Response to Planning application from Hertfordshire County Council (T and CP GDP Order 2015)

District ref: 6/2020/2581/FULL
HCC ref: WH/3817/2020
HCC received: 13 October 2020
Area manager: Matthew Armstrong
Case officer: Ania Jakacka

CHANCELLORS SCHOOL PINE GROVE HATFIELD AL9 7BN

Laying of grasscrete for the provision of additional car parking and laying of tarmac pedestrian path. (Temporary period of three years).

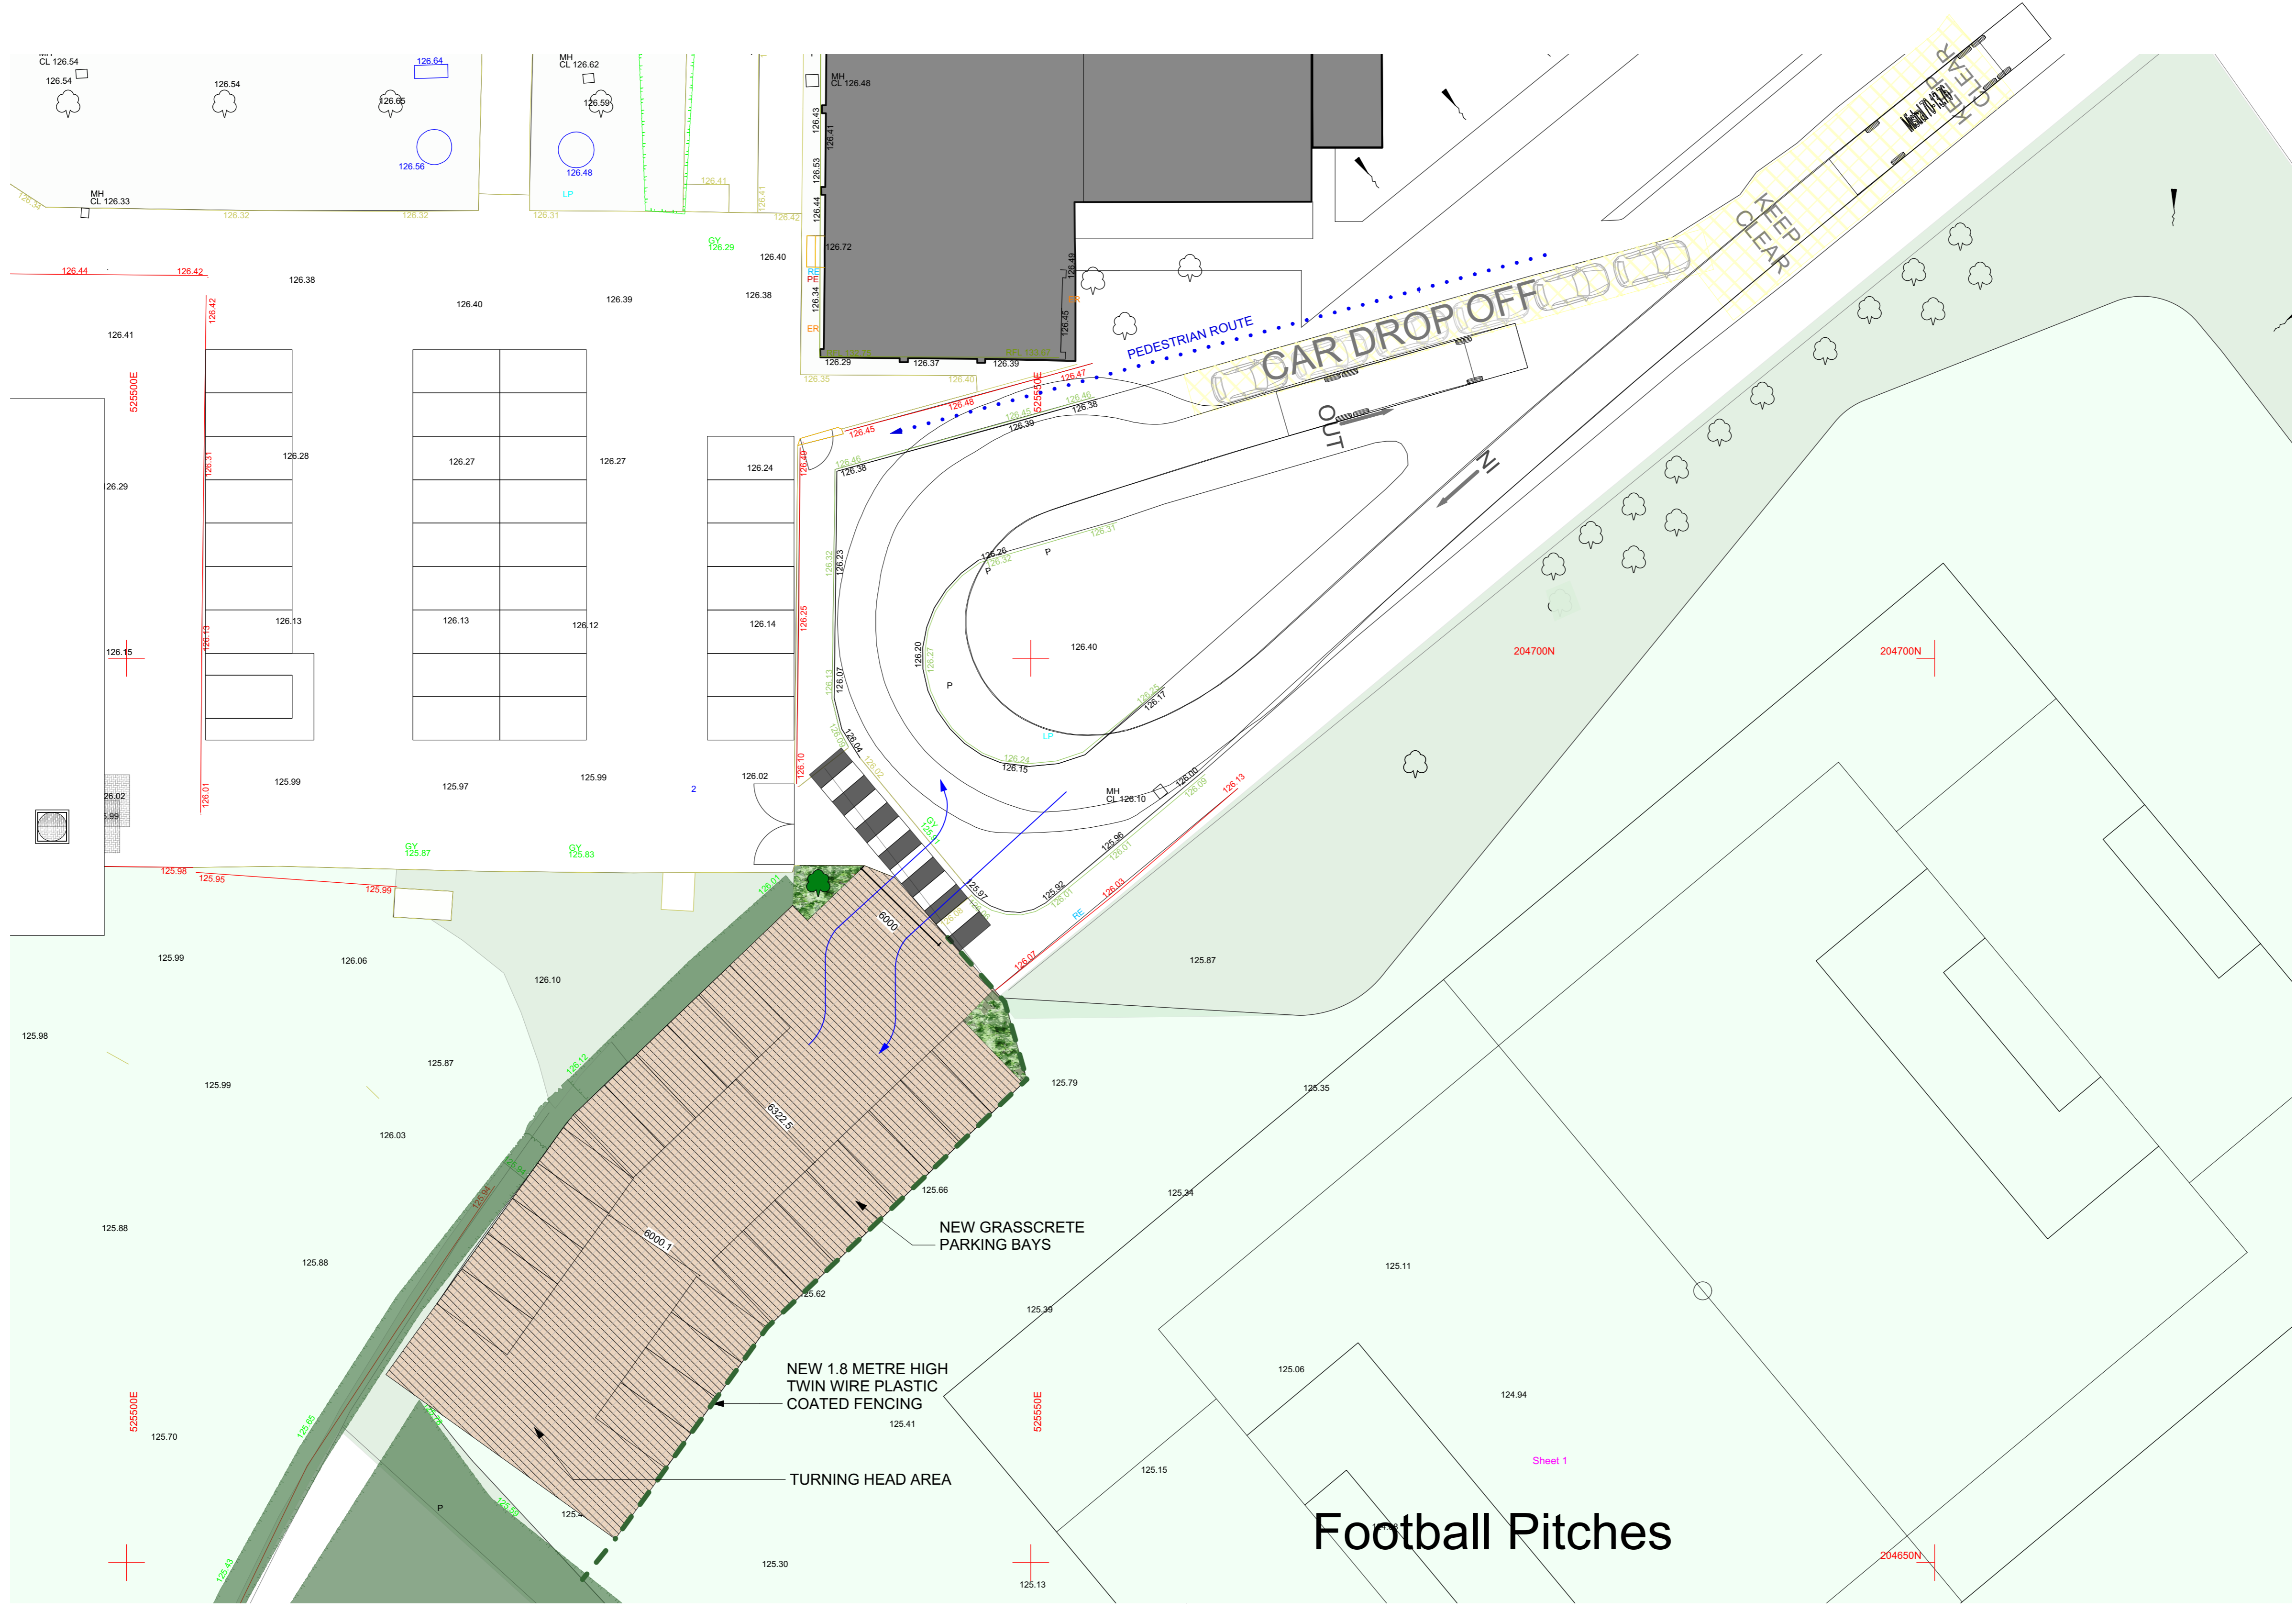
Whilst the Highway Authority raises no objection in principle to the temporary parking being provided as a way of alleviating a temporary issue with parking, concerns are raised with the design of the

western car park and lack of reversing space and interference of the new seven "car drop off" spaces with the bus access/pick up/drop off.

For this reason, vehicle swept paths will be required to demonstrate that vehicles will be able to access and turn around and leave in a forward gear the new 27 spaces located in the western car park without the need to reverse out blindly onto the zebra crossing. A single deck bus swept path would also be necessary to confirm that it can continue to use the one- way system unobstructed.
